Your reference: EN020022
Our reference:
DCO/2018/00016

The Planning Act 2008, AQUIND Limited, proposed AQUIND Interconnector Project Deadline 6 Response

This document comprises the MMO comments in respect of the DCO Application submitted in response to Deadline 6.

Drawing file: EN020022 / EN020022-000954-6.8.2.8.1 HRA - Vol 2 - Figure 8.1 Location of In Combination Marine Projects.pdf

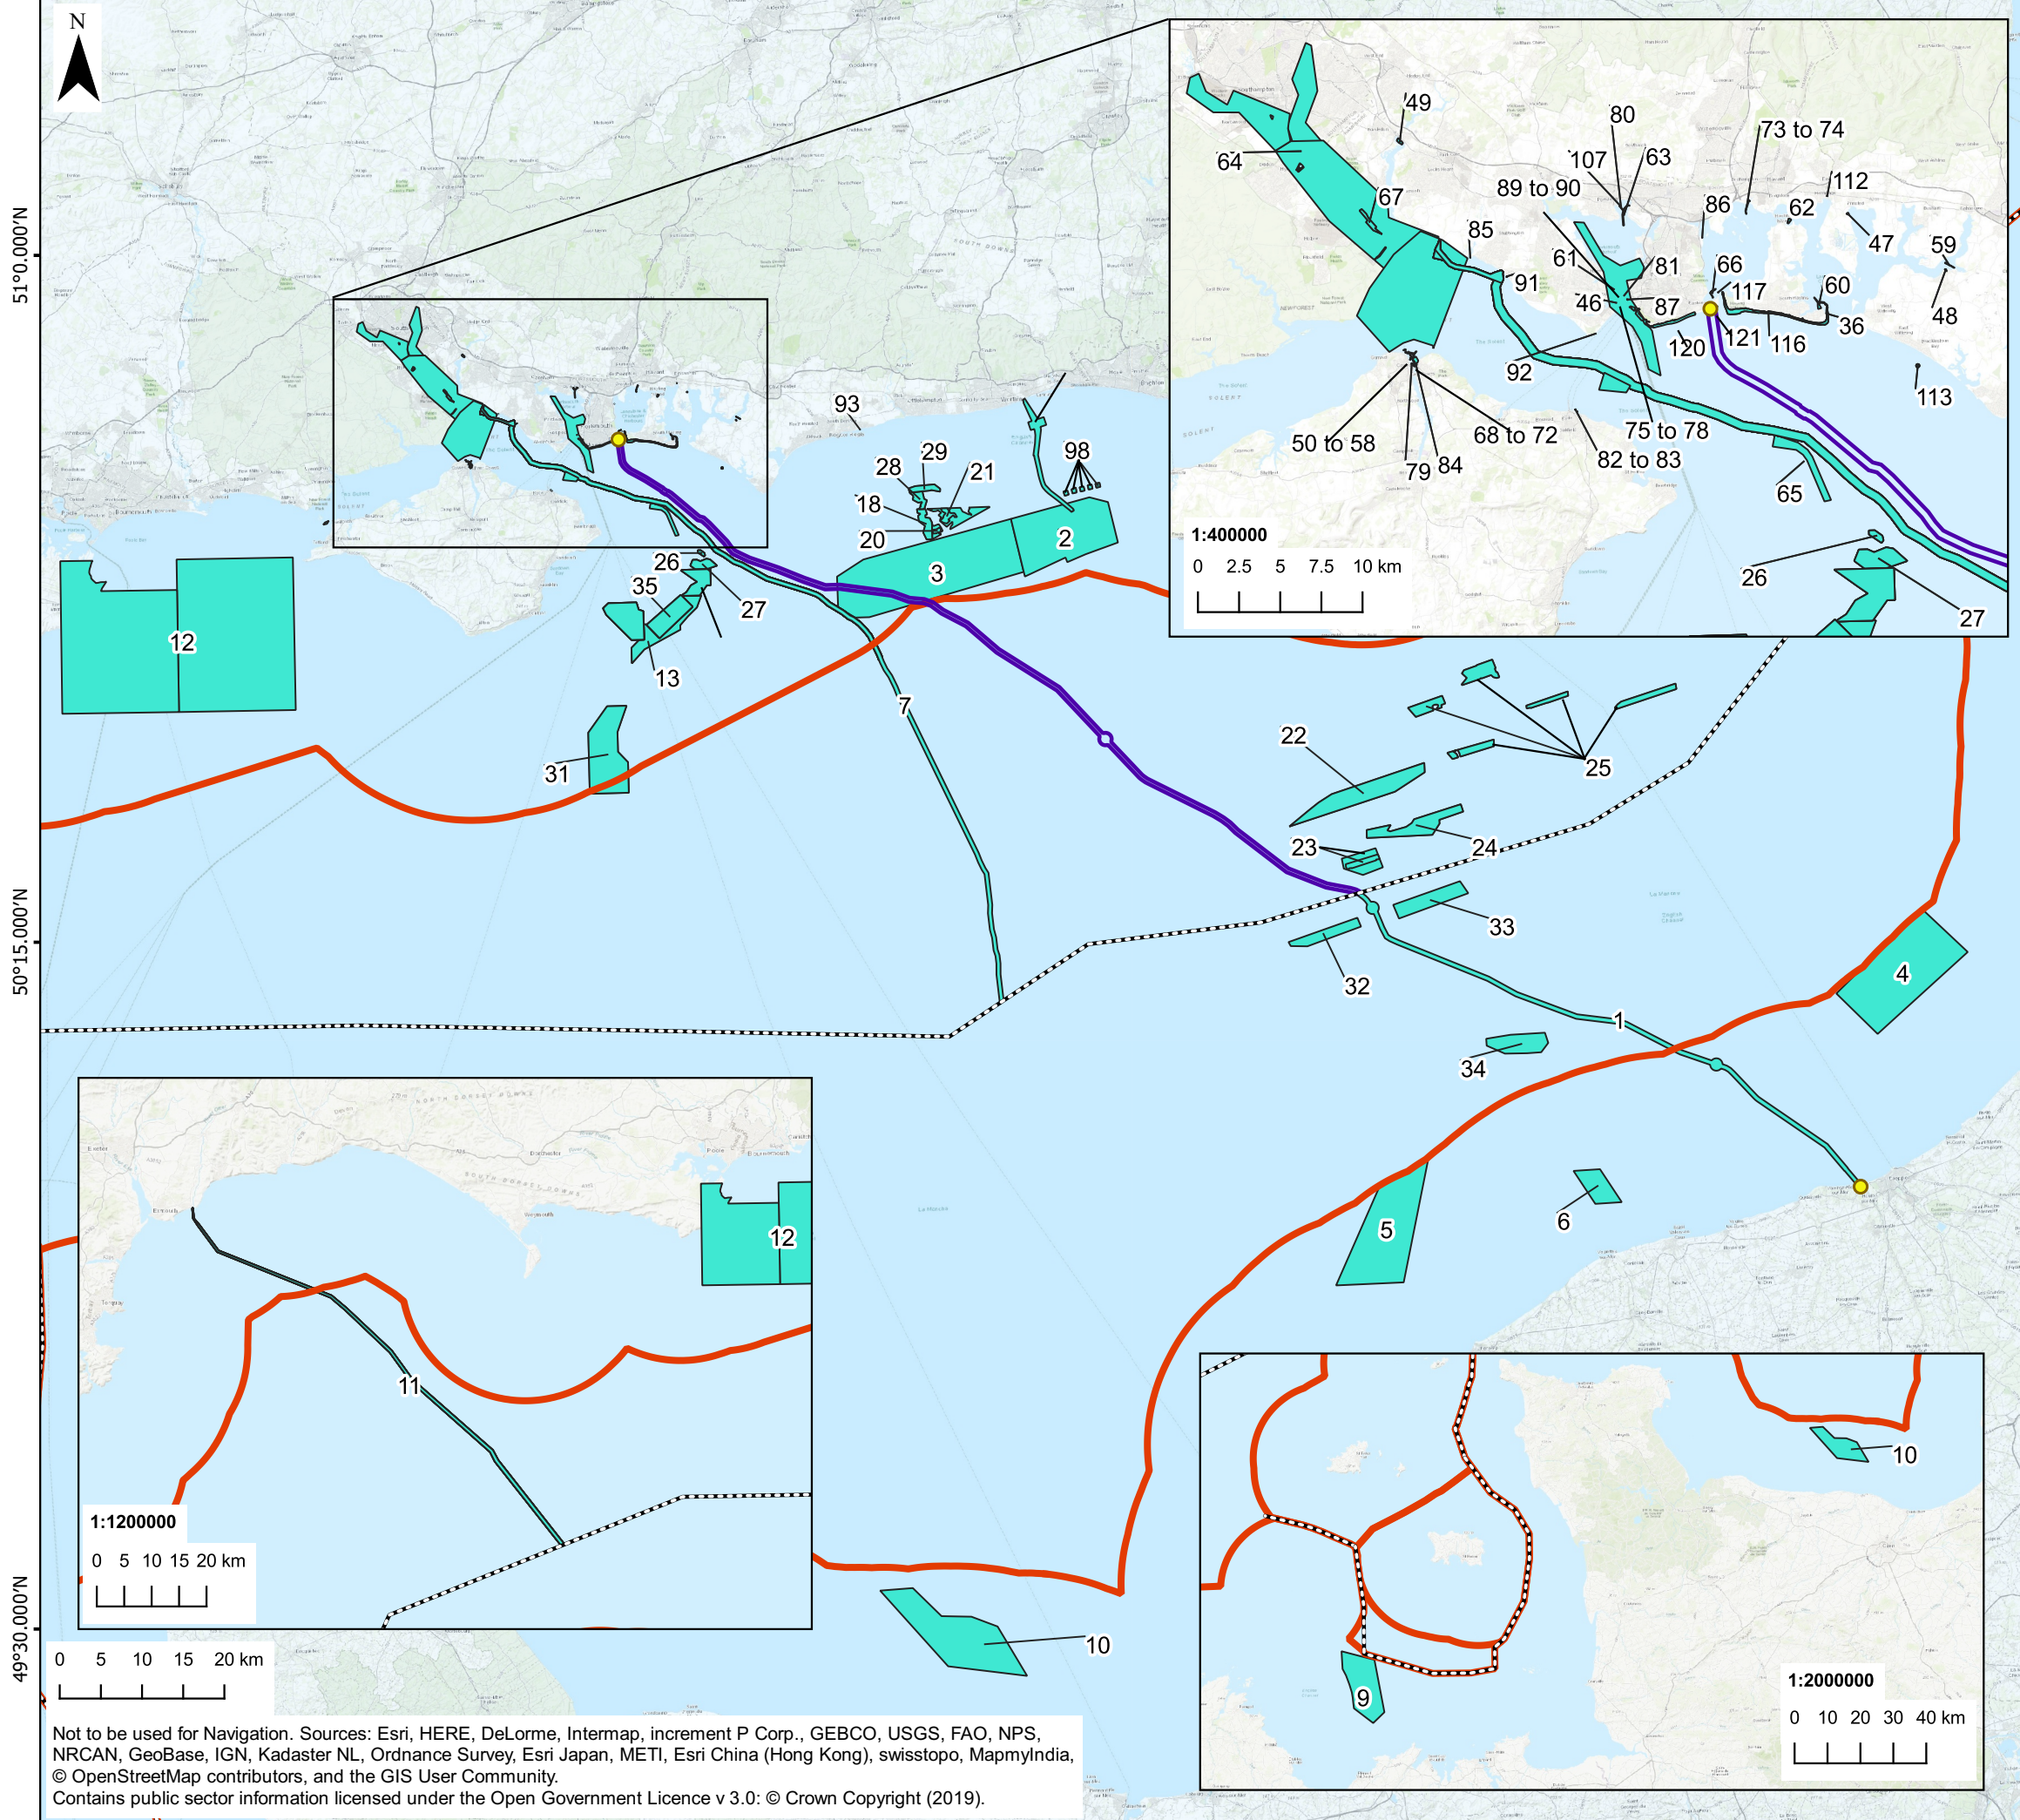
- *Whilst it is stated that a precautionary approach was taken to determine the study areas for the baseline, could the Applicant provide reassurance that Figure 8.1 does*

not need updating to reflect the regional boundaries used in the ES? Are the MMO and Natural England content with the extent of the study area?

MMO is content with the study area.
